COUNTY COUNCIL'S RESPONSE TO CONSULTATION ON THE FOLLOWING DEVELOPMENT PROPOSAL

Application No: 19/01746/OUT

Proposal: Outline planning permission (with all matters reserved excluding access) for up to 10,200sqm of B1 development (B1a and/or B1b and/or B1c); access and associated landscaping and infrastructure works

Location: Land Adj To Promised Land Farm, Wendlebury Road, Chesterton

Fig. 27 Proposed infrastructure plan, DTA drg no 19539—11—12 Wendlebury Road Site Access Roundabout

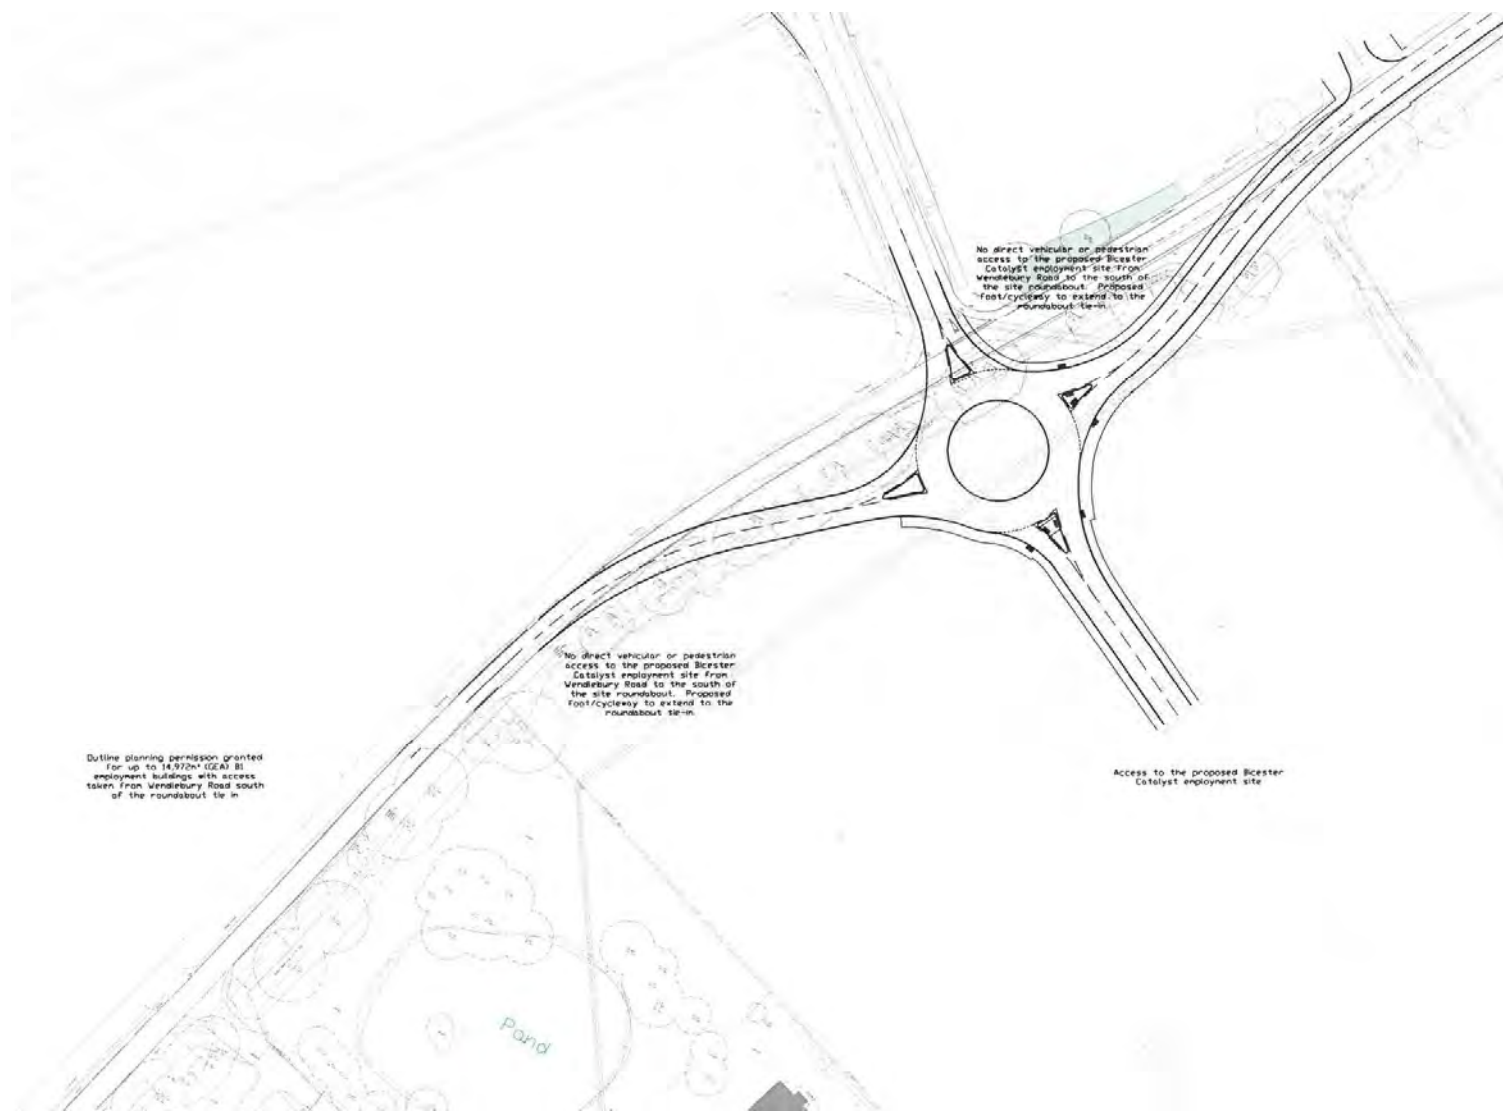
A new 4-arm mini roundabout was agreed as part of the Bicester Gateway Phase 1 development and will form the principle site access to the B1 development on phase 1 (Phase 1b). The access for this application would require a new standard roundabout at approximately the same location, as the mini roundabout would not provide sufficient capacity. (The new roundabout would serve the Wendlebury Road (North and South arms), site access and the Vendee Drive roundabout link will form the east and west arms respectively.

Whilst this new roundabout was consented as a mini-roundabout (in Bicester Gateway Phase 1 development) as mentioned in para 3.2.2 of the Transport Assessment (TA), in order to make accessibility for traffic associated with Bicester Gateway Phase 2, it was considered appropriate for this to be upgraded to a standard /conventional roundabout. This arrangement may require the development to dedicate some of the land to highways in order to realign Wendlebury Road and also accommodate the new roundabout.

It is observed through supporting documents that the application site redline does not extend to cover all of the land required for the new roundabout and realignment of Wendlebury Road should this application be considered independently. The TA suggests that the new roundabout (including realignment of Wendlebury Road) shall be required for all scenarios (See below). It raises concern how this application site (Site B) shall be accessed through Site A if brought forward on its own? This would surely need to be in the context of an agreed masterplan. **(Reason for objection)**

Fig. 28 Site B location plan

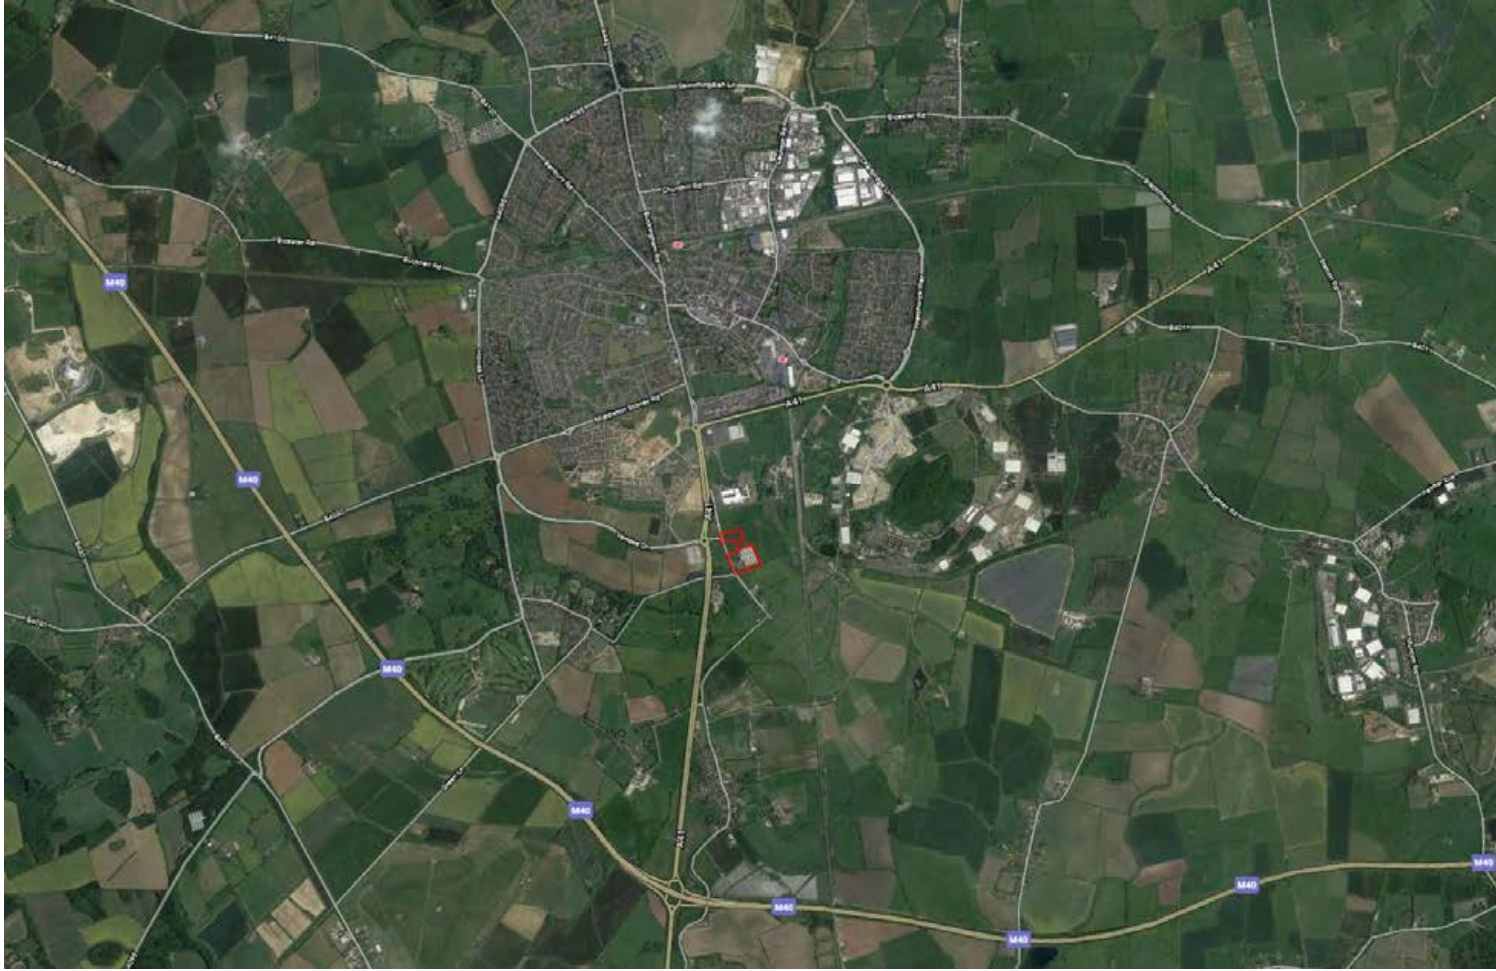
Again, the “Application 2” site redline shown in the Site Location Plan (Drwg no. 18022-TP-111) does not corroborate with any of the development scenarios shown above. These contradictions need to be addressed for a robust assessment of the development’s transport impacts on the local highway network
